## OFFICIAL NOTIFICATION OF DECISION

**Project# PR-2020-004030**  
**Application#**  
**SI-2020-00540 SITE PLAN – DRB**

For all or a portion of: **TRACT E-1 PLAT OF TRACTS D-1, E-1 AMAFCA BLACK ARROYO CHANNEL ROW PARADISE HEIGHTS**, zoned MX-M, located at **GOLF COURSE RD NW between GOLF COURSE RD NW, BLACK ARROYO and WESTSIDE BLVD** containing approximately 8.77 acre(s). (A-12,13)

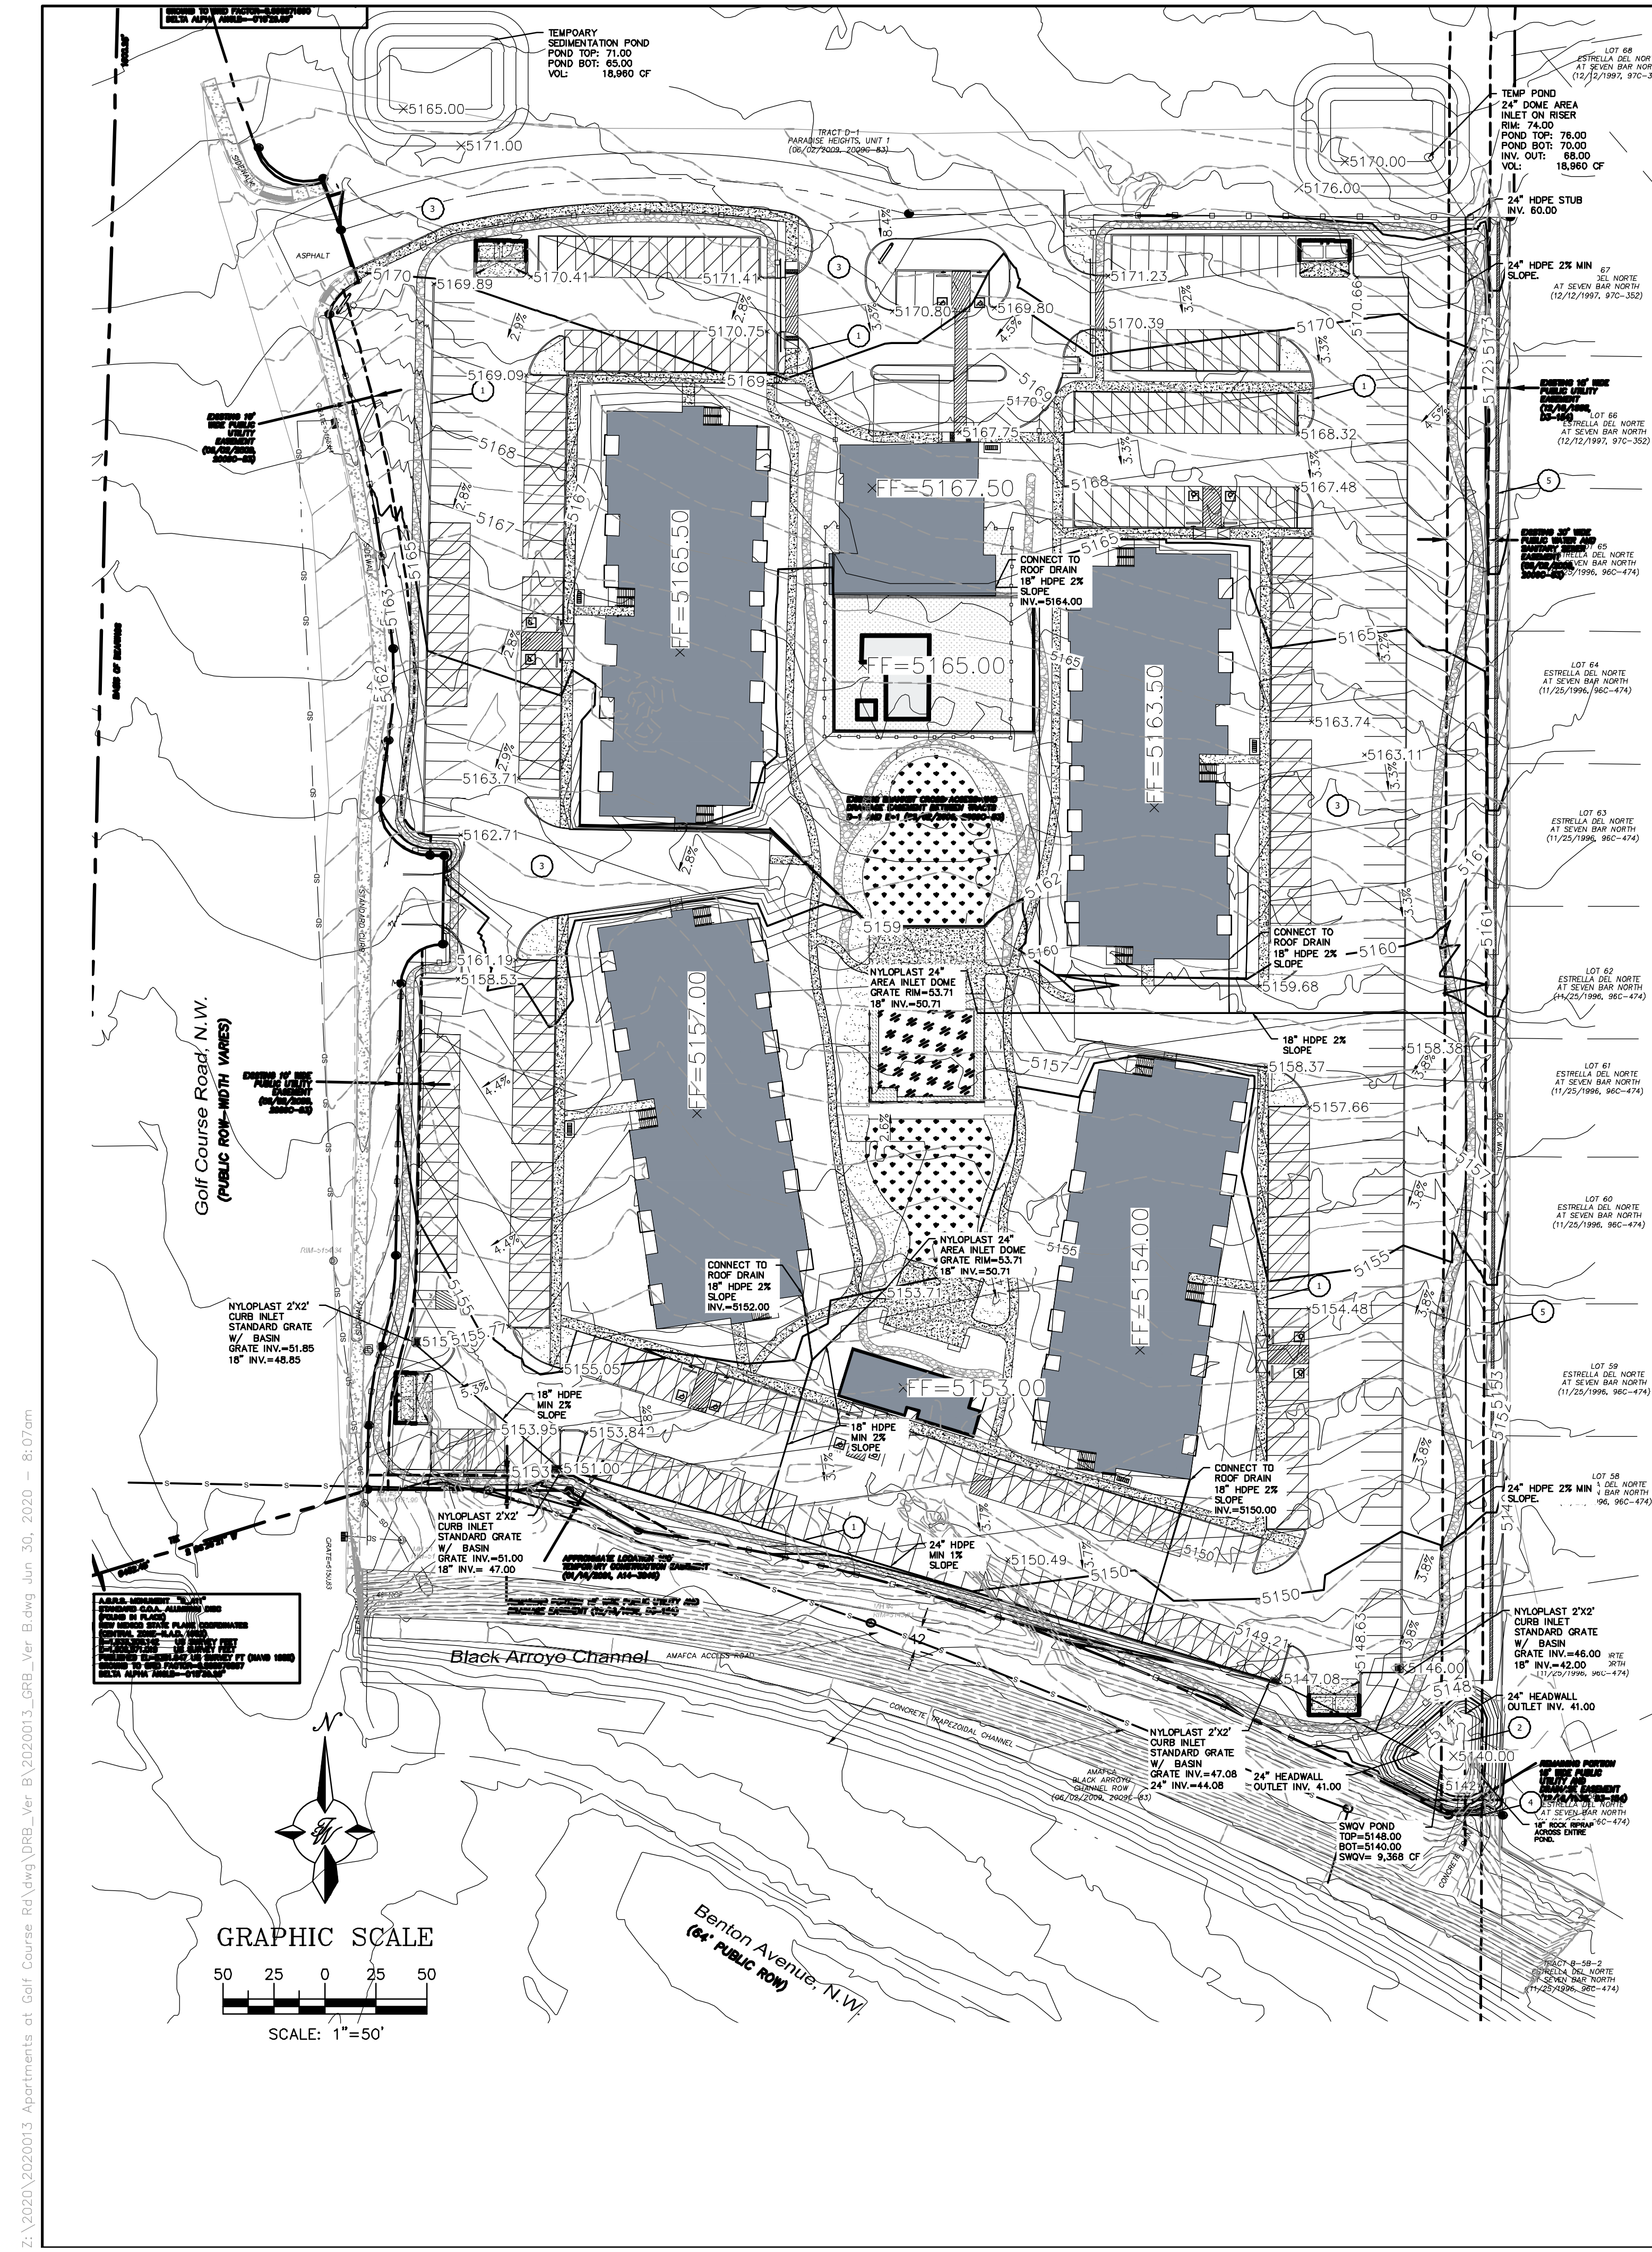
1. This Site Plan is valid 5 years from DRB approval (9/30/2020). An extension may be requested prior to the expiration date.
2. A note will be added to the site plan: "Pursuant to IDO 5-6(C)(5)(b) Organic mulch, such as wood chips or pecan shells, is required as ground cover for the portion of any landscaped area surrounding the vegetation root ball, as well as beneath the entire tree canopy or dripline, in each required landscape area."

Conceptual Landscape Plan

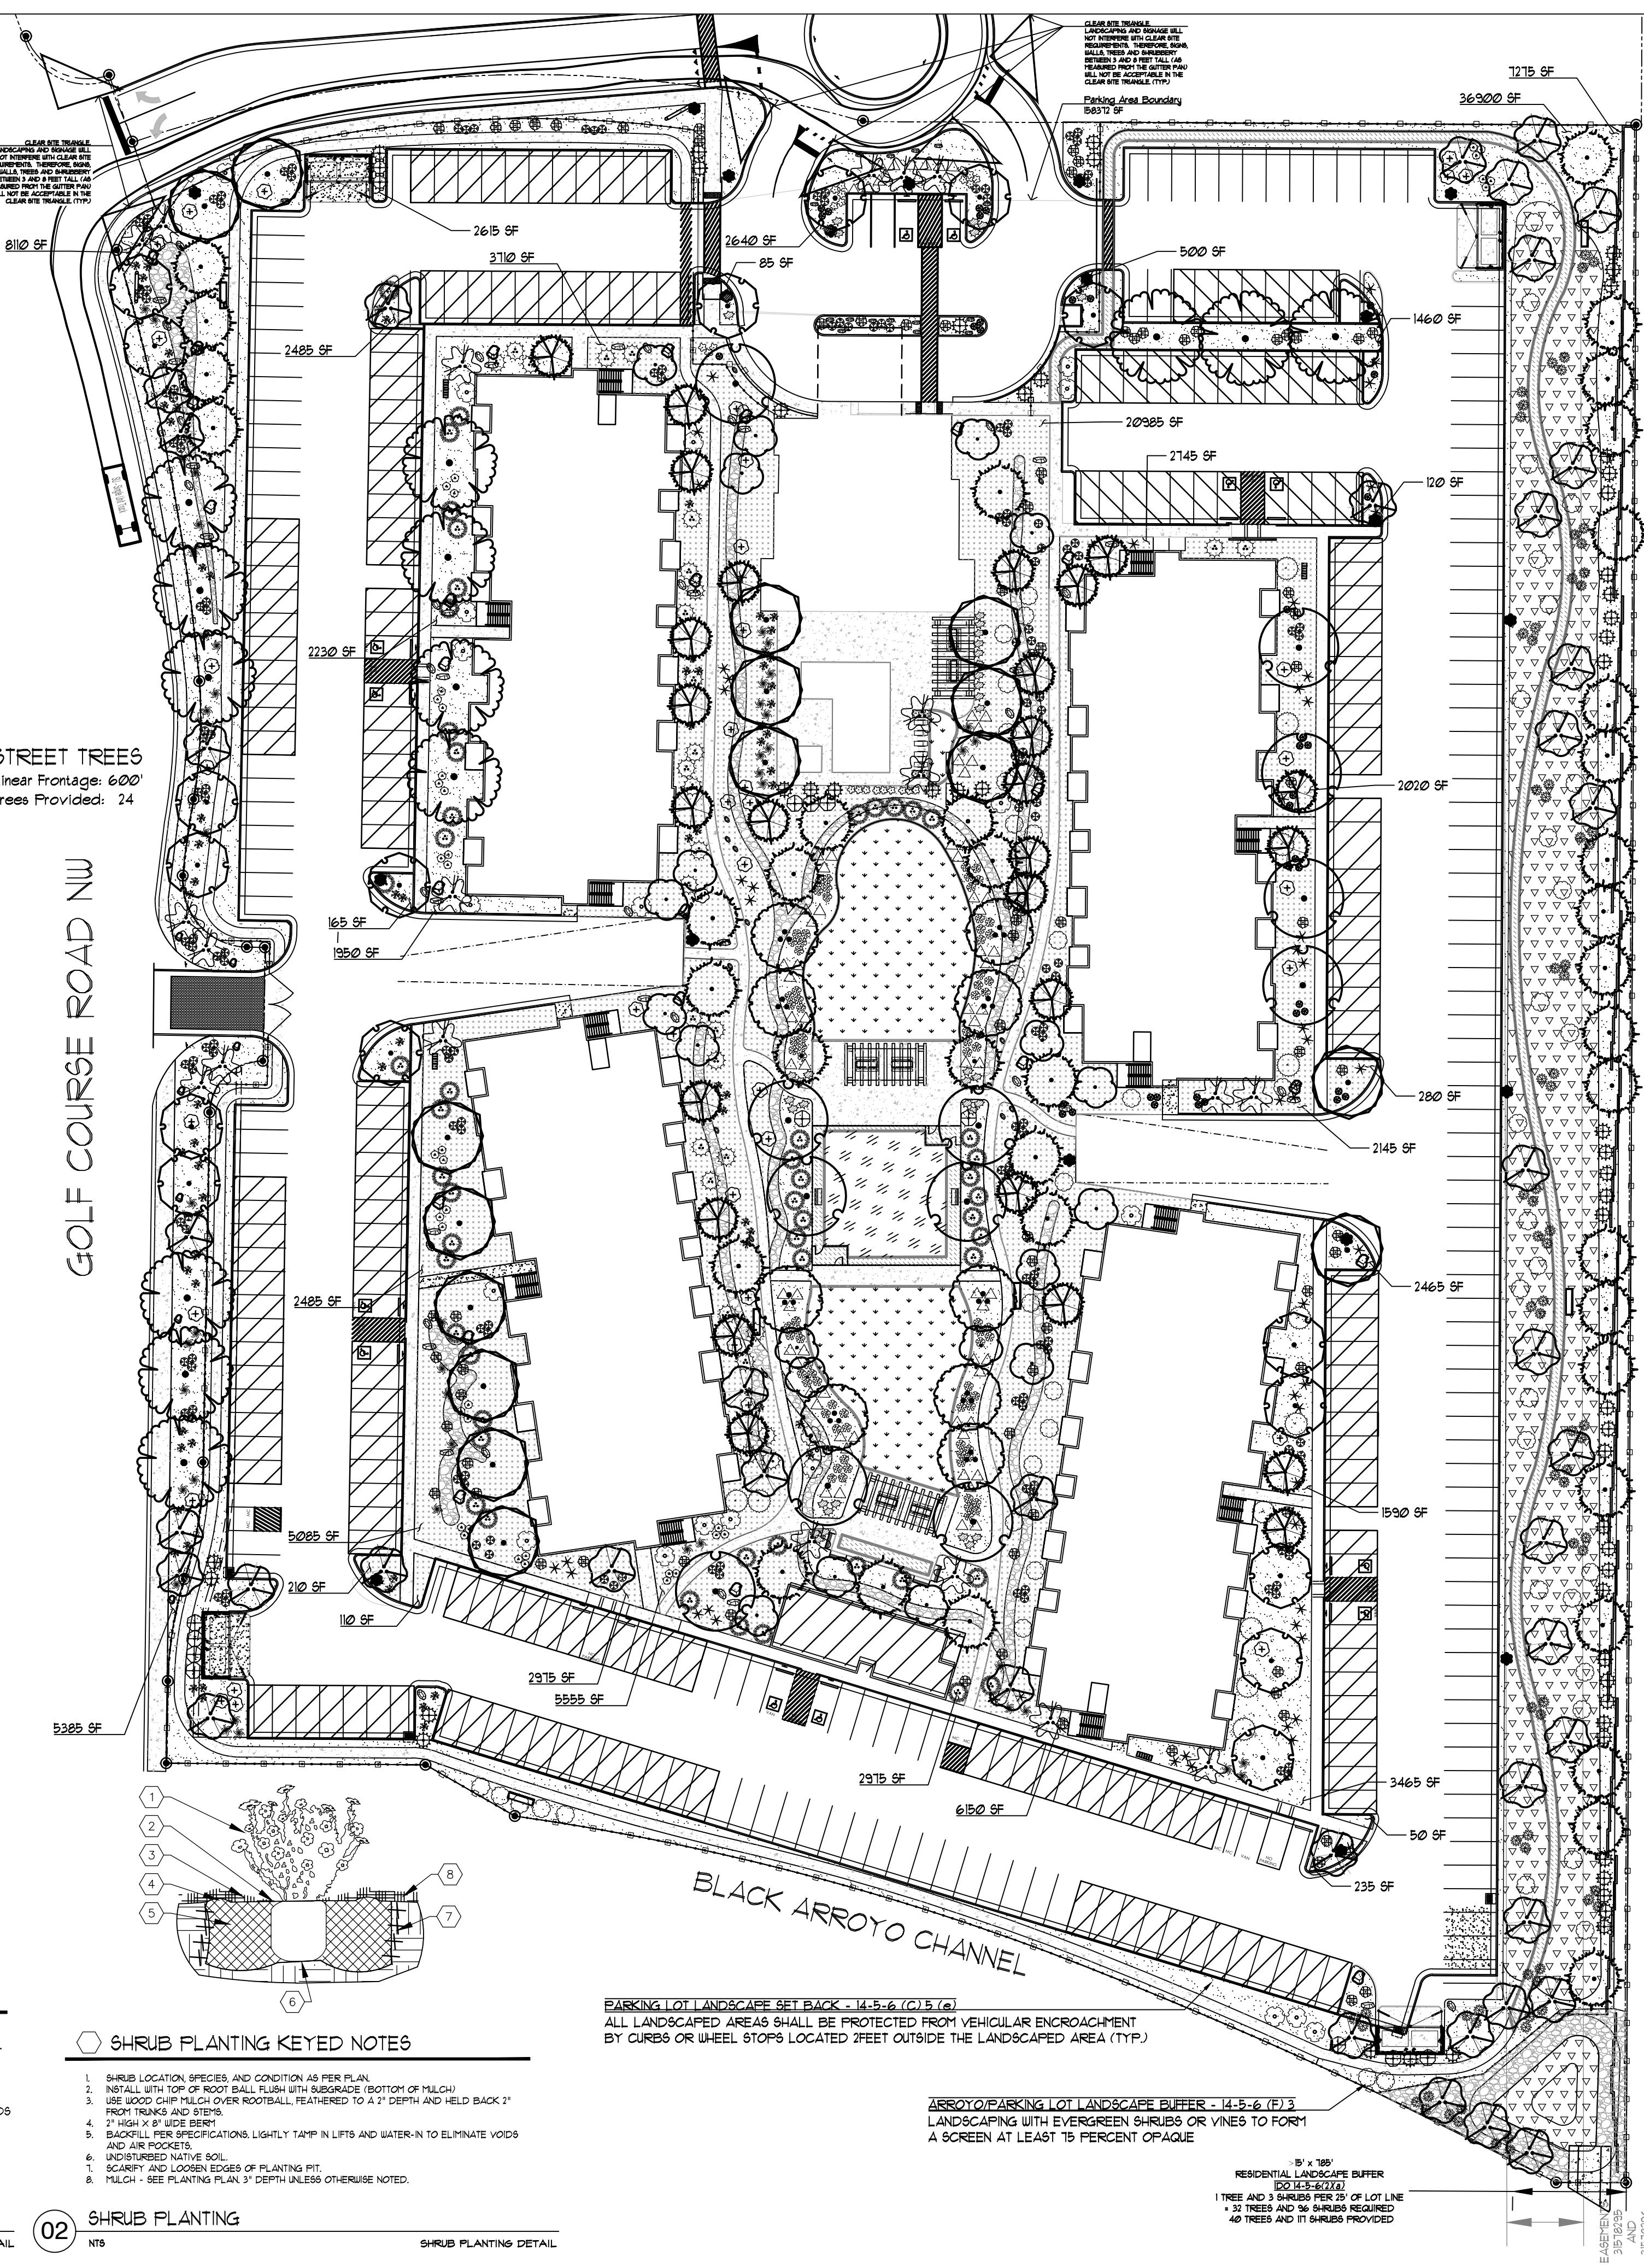
3. Final sign off is delegated to ABCWUA for execution of the development agreement.
4. Final sign off is delegated to Planning to finalize the wall and landscaping in the 15 foot portion of the landscape buffer adjacent to the existing residential subdivision.
